To:	Sean Kearney	At:	Doma Group
From:	Benjamin Park	At:	SLR Consulting Australia Pty Ltd
Date:	22 October 2020	Ref:	620.30106-M01-v2.0 42HSD Traffic Engineering Response 2020 10 22.docx
Subject:	42 Honeysuckle Drive Hotel Development Response to Submissions Traffic Engineering Matters

1 Introduction

1 Section
Carpark Ramp 02
1:50

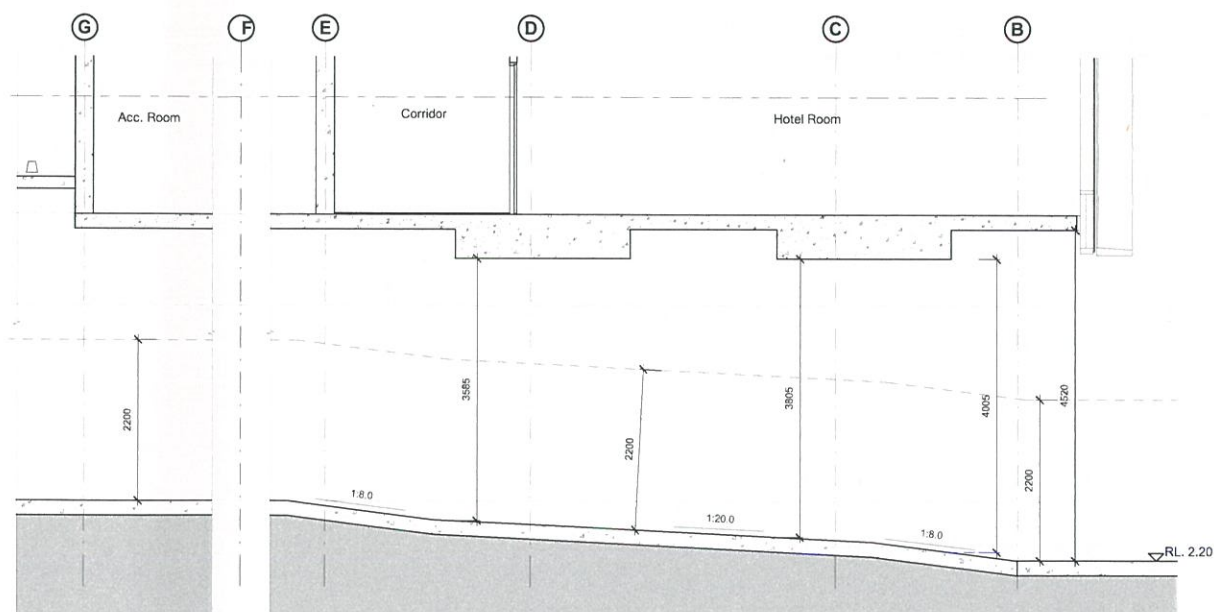
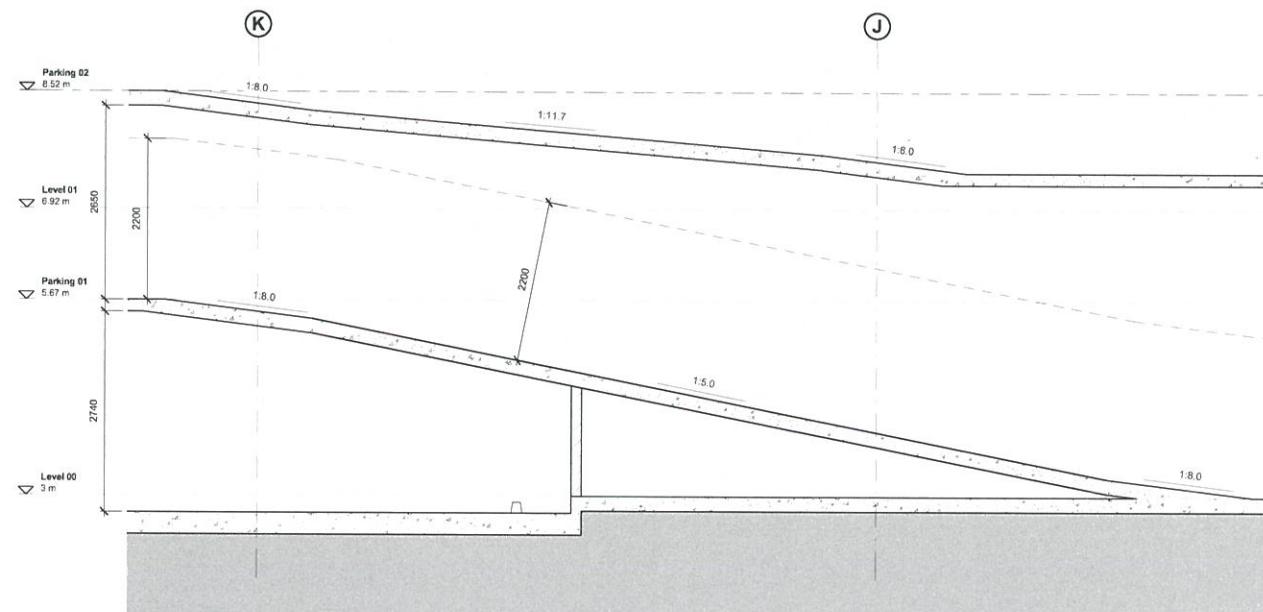
N/A	<p>DPiE should have consideration for appropriate sight line distances in accordance with Section 3 of the Austroads Guide to Road Design Part 4A (Unsignalised and Signalised Intersections) and the relevant Australian Standards (i.e. AS2890:1:2004) and should be satisfied that the location of the proposed driveway promotes safe vehicle movements.</p>	Section 7
